GOVERNMENT ARCHITECT NEW SOUTH WALES

MARTIN PLACE OSD DRP – SESSION 13 05.05.20

SSDA Condition B13 –Through Site Link

MARTIN PLACE OSD DRP
SESSION 16 20.10.20

Public Art Location plan

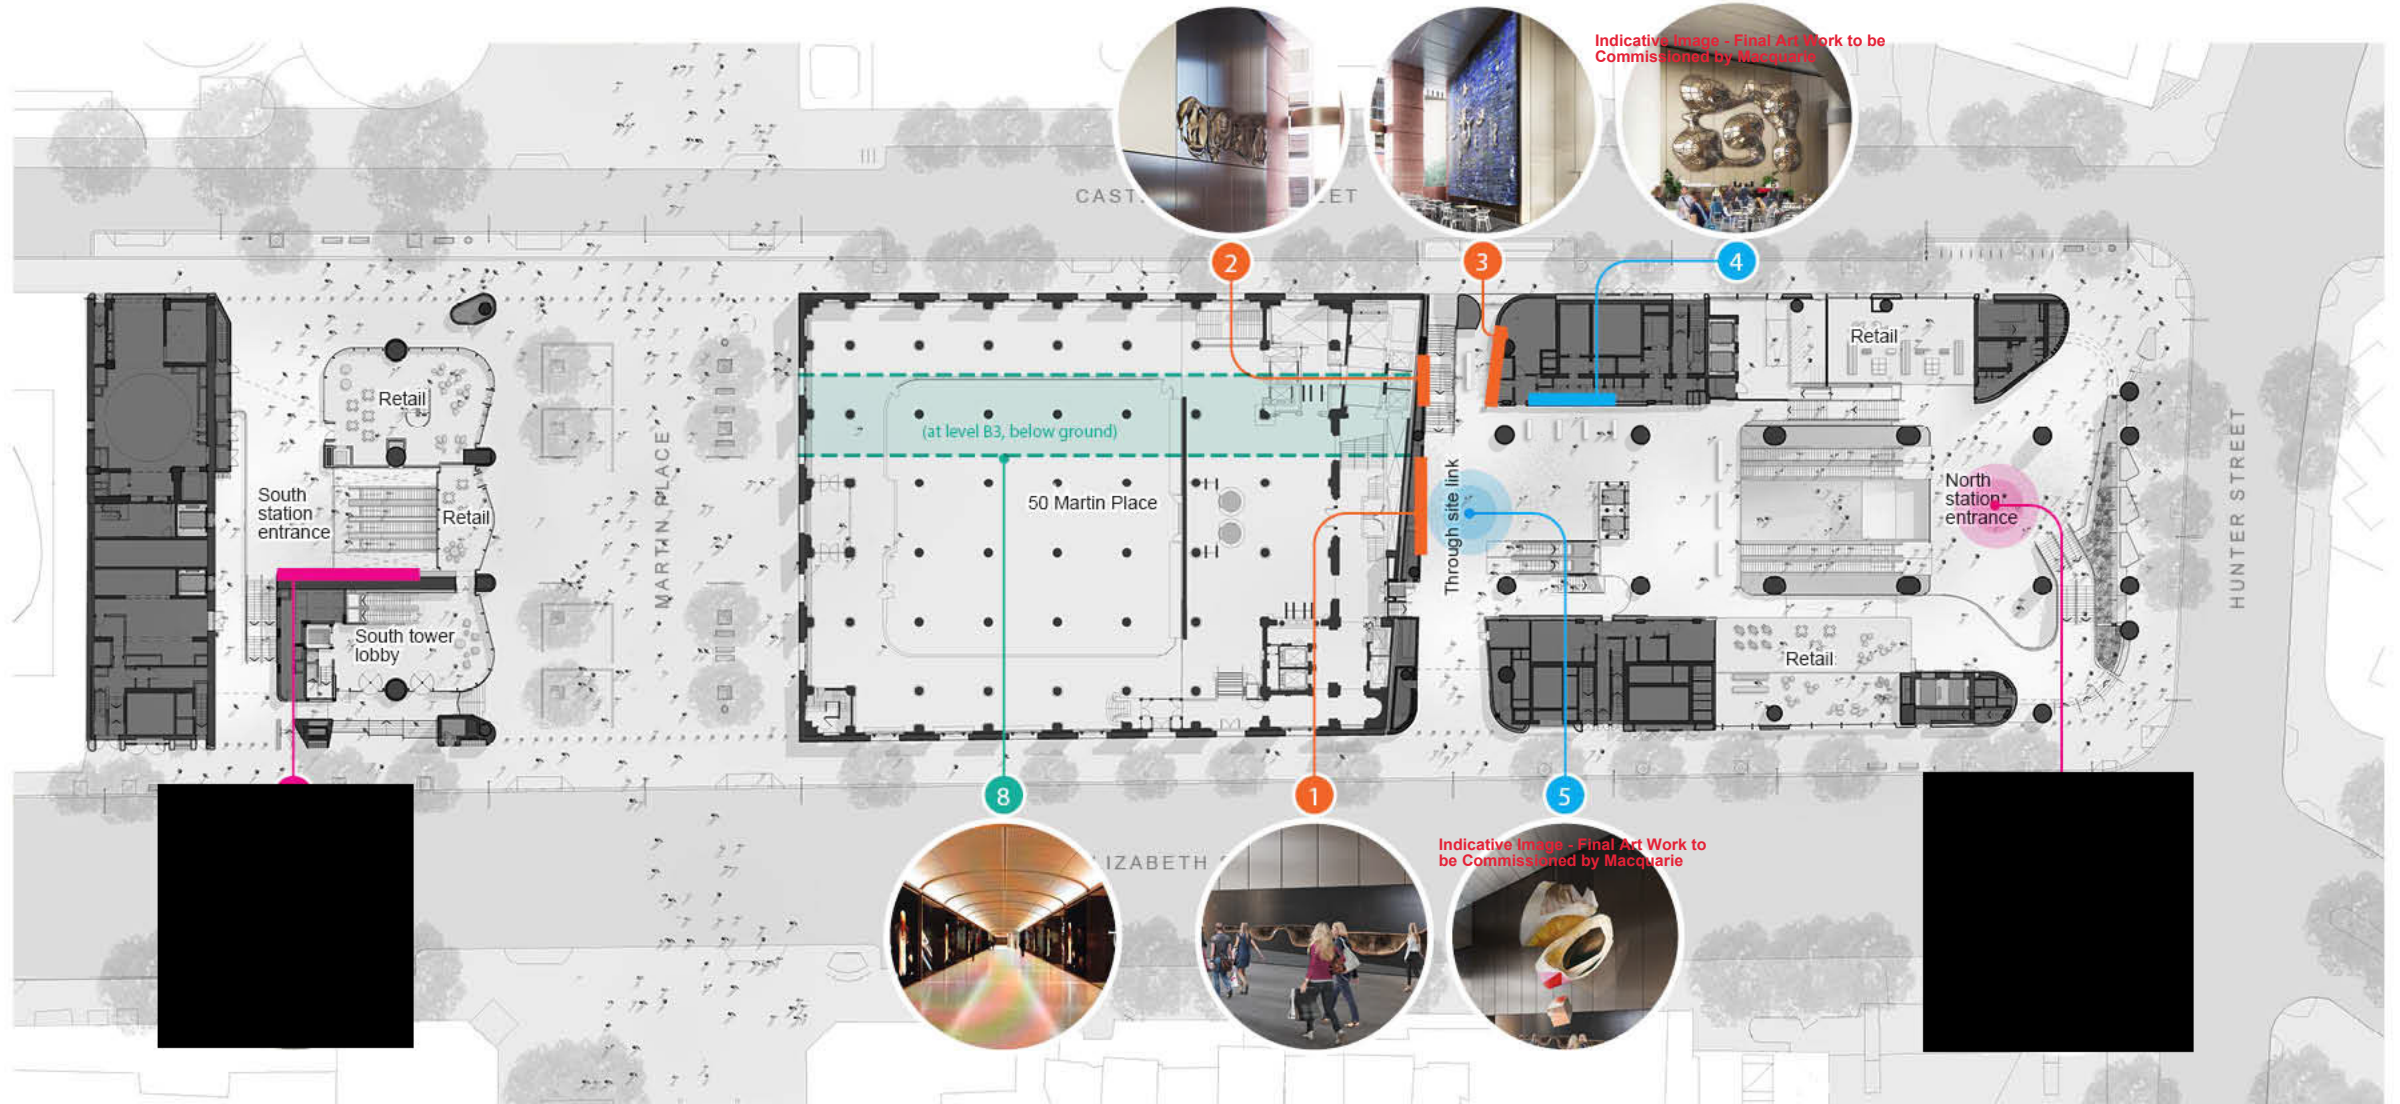
- The precise positioning of the Moebius sculpture suspended above the north station entry requires reexamination to ensure unimpeded sightlines from eye level from all angles – in animations presented it currently appears too high for full views from the southern gallery level

- Opportunities for the public to access information about artworks and gain further understanding through physical and digital means should be incorporated

- Mobius sculpture is suspended so that it can be viewed in full from the upper viewing level (view not blocked by the ceiling or bulkheads). Panel confirmed the matter has been addressed and supports the proposed approach.
- Item can be closed.

Infrastructure to support public activation Plan

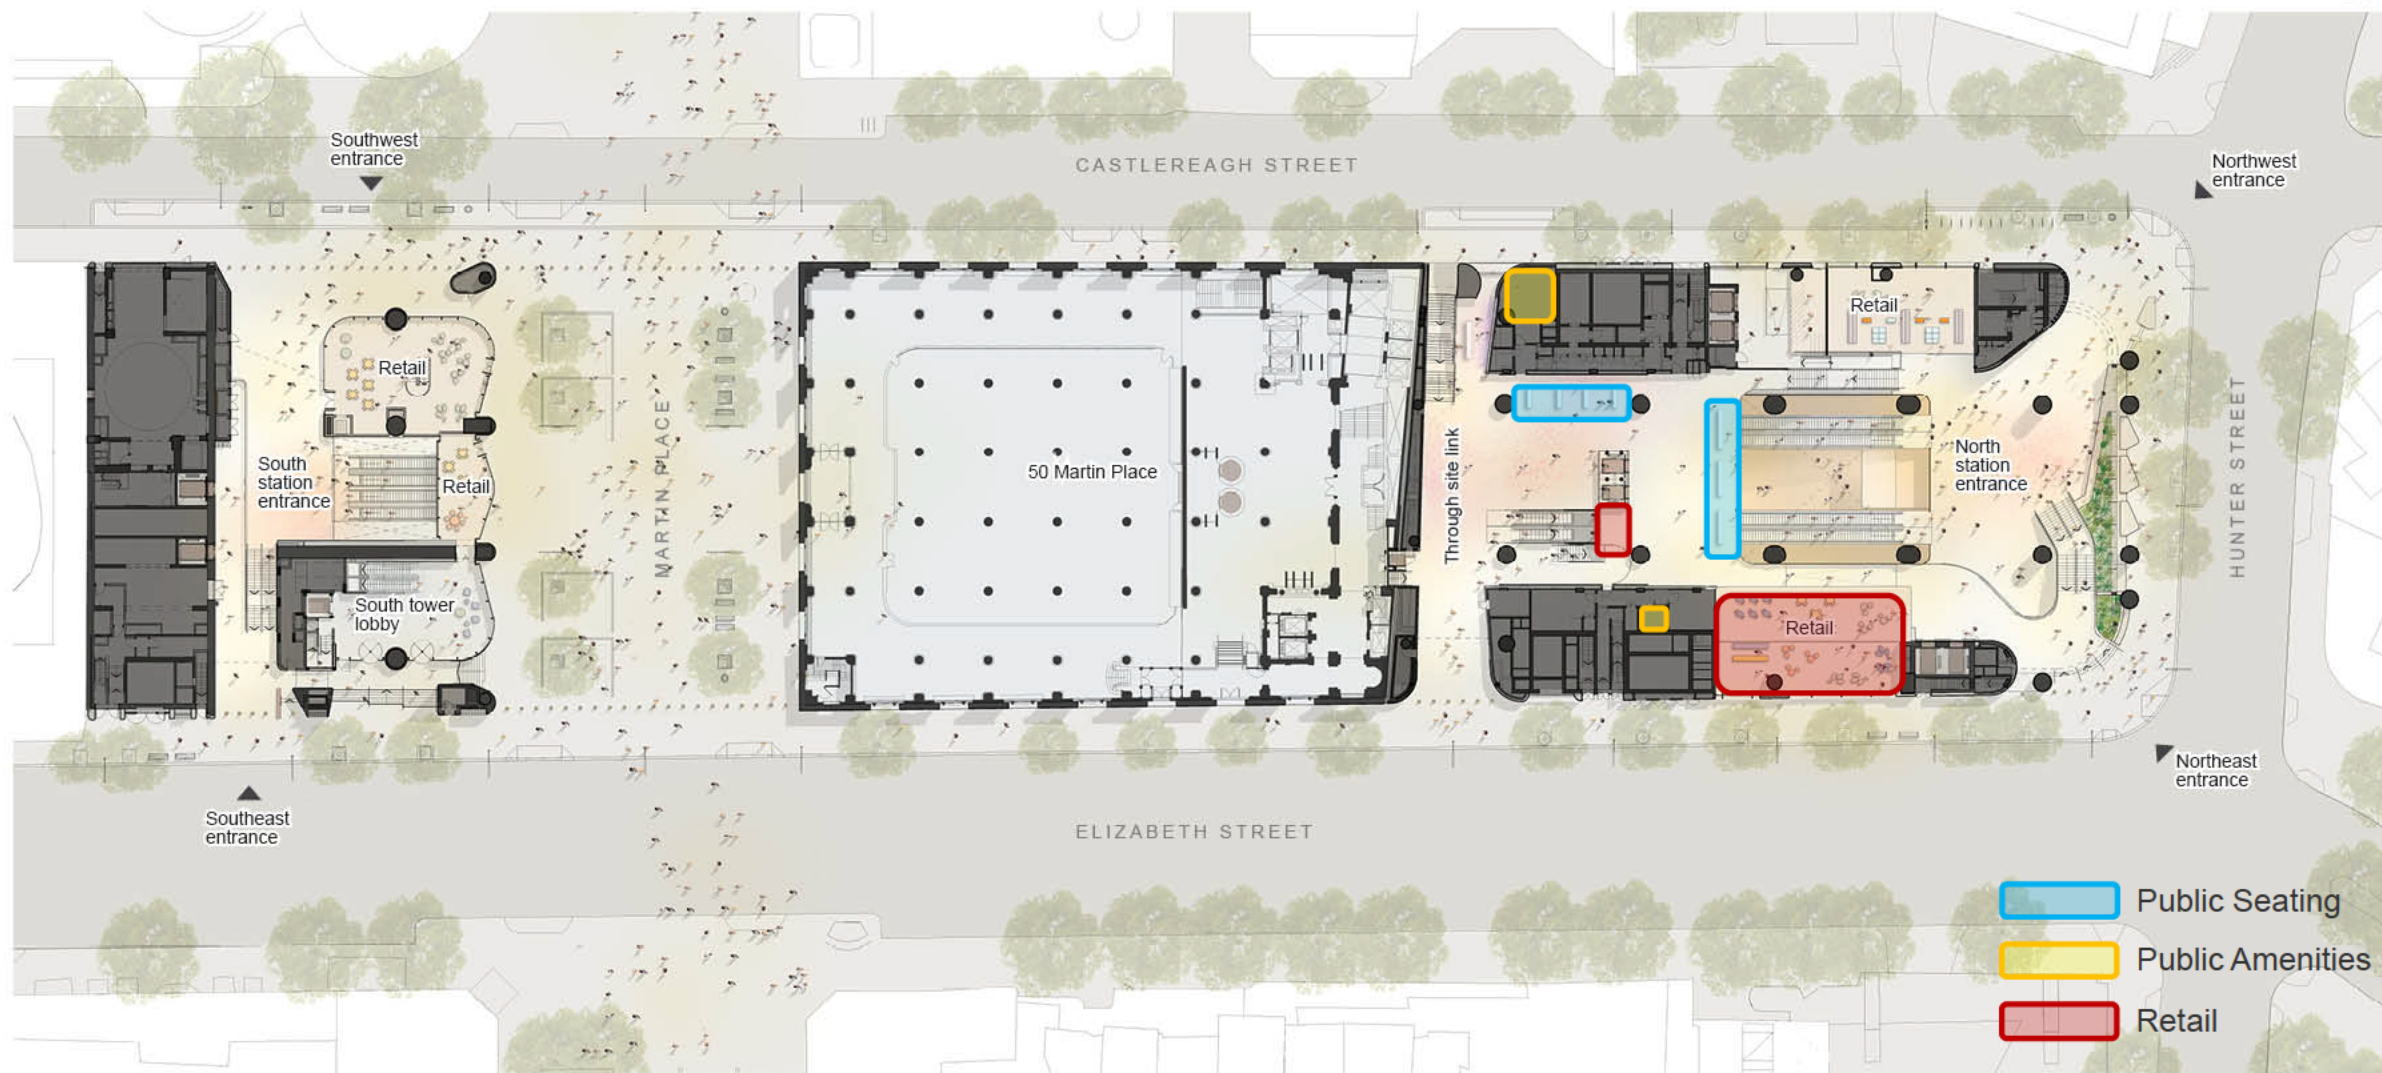
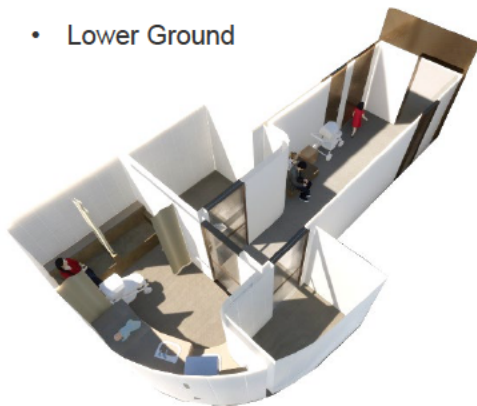
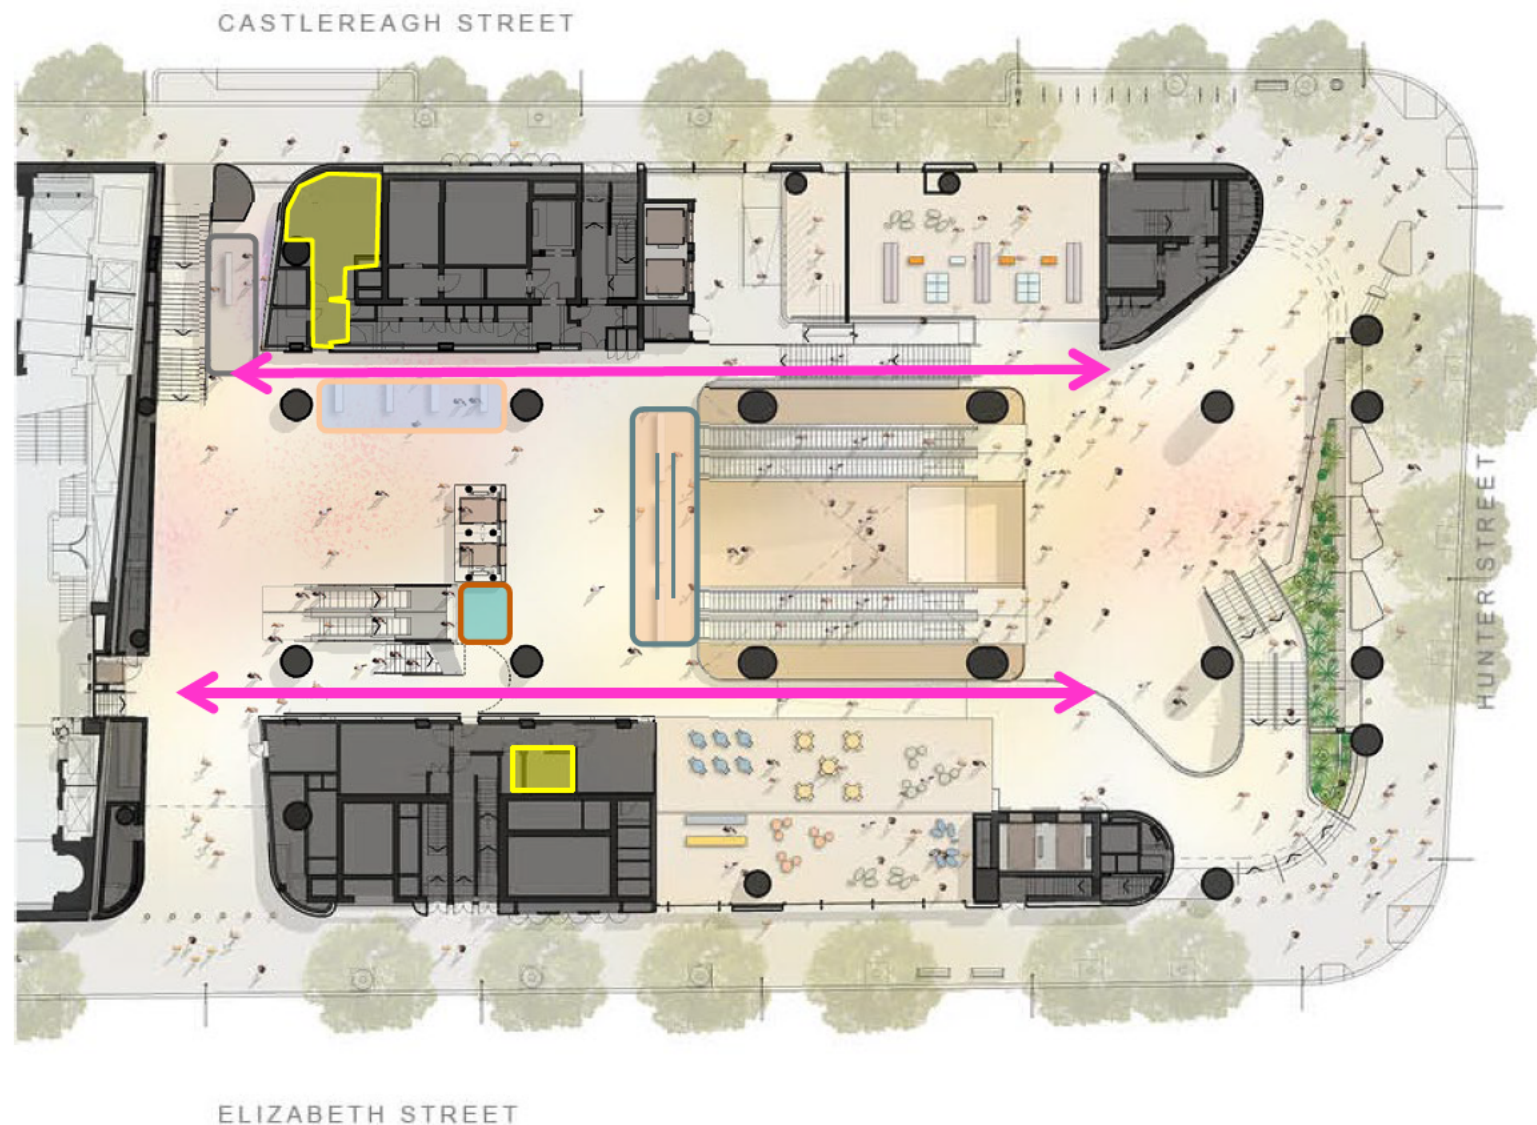
- Confirmation is sought on how the number of public WCs proposed has been calculated. Provision of amenities must be sufficient to avoid queues spilling into adjacent public spaces and circulation zones

- Design of signage, integration with the architecture and ease of wayfinding for members of the public seeking toilet facilities requires

clarification and further development. Ensure integration with broader signage strategy and materials palette

- Details of public seating and fixtures to promote uses as described (meeting place, people watching vantage point, amphitheatre – Town Hall Steps precedent) are requested for future presentation to the DRP

- Approach to the location and number of the amenities was supported.
- Item can be closed.

Function and entry experience Plan

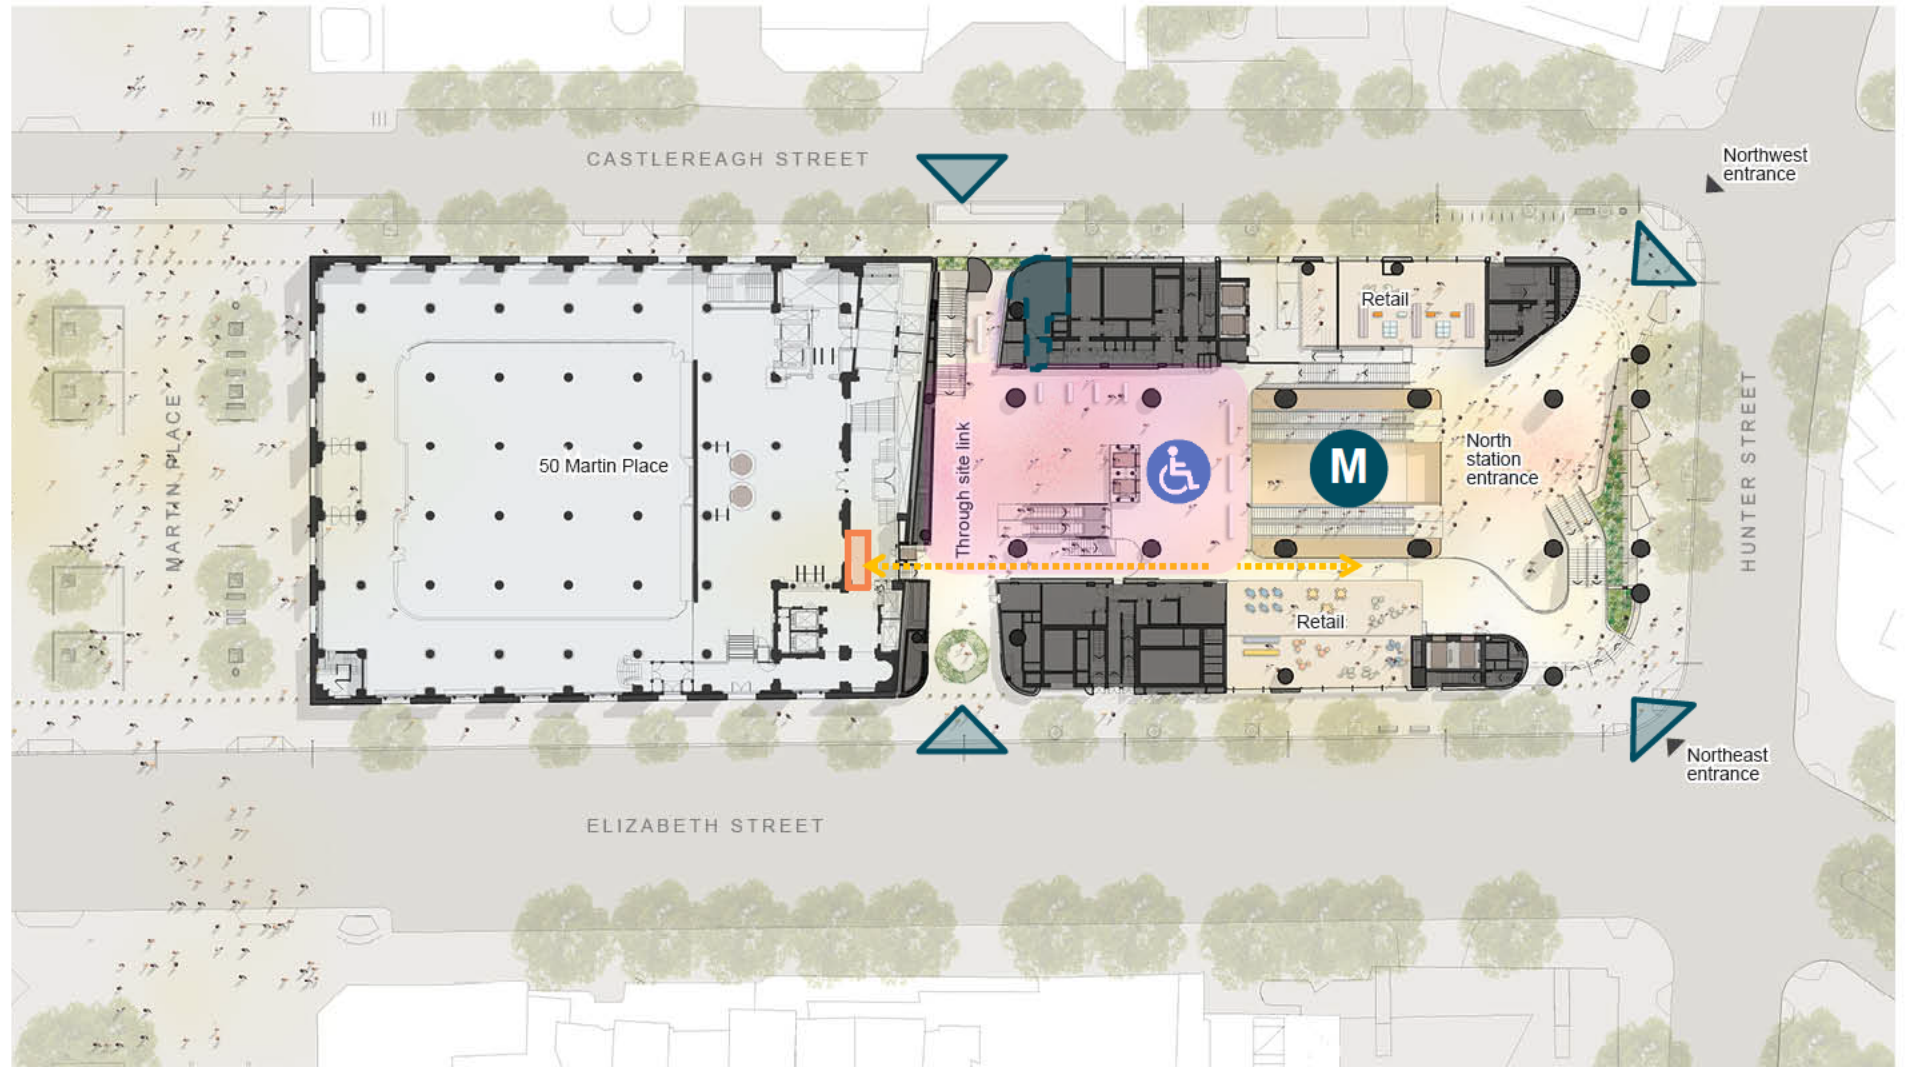
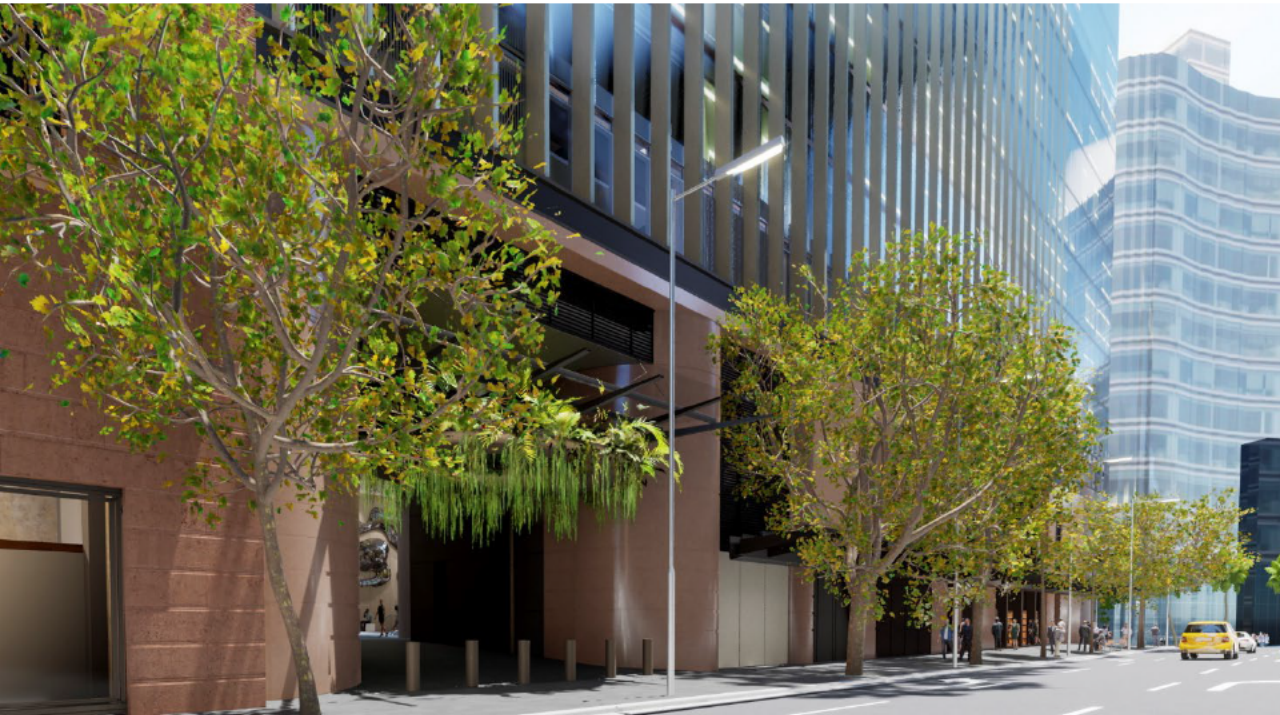
- c) Entry Experience
 - The overall entry experience as presented is supported
 - More detail is required on wayfinding and signage elements
 - The suspended landscape donut above the eastern entry requires further explanation

- Integration of the suspended planter with the awning over, treatment of irrigation, drainage, lighting, and materials need to be clearly explained
 - The overall intention for landscaping, including entry landscaping, should be illustrated in future renders

- Lighting to the planter element to ensure shadows to floor surfaces are acceptable.
- Diameter of the connecting arms and connection detail to the adjacent walls.
- Finish of the ring.
- Panel noted that earlier concepts had illustrated the planter centered on the awning structure above and observed that the current presentation material suggest the planter and awning were now offset. It was queried whether in the offset arrangement, the balance between two strong elements (planter + awning) was potentially compromised. This should be tested.
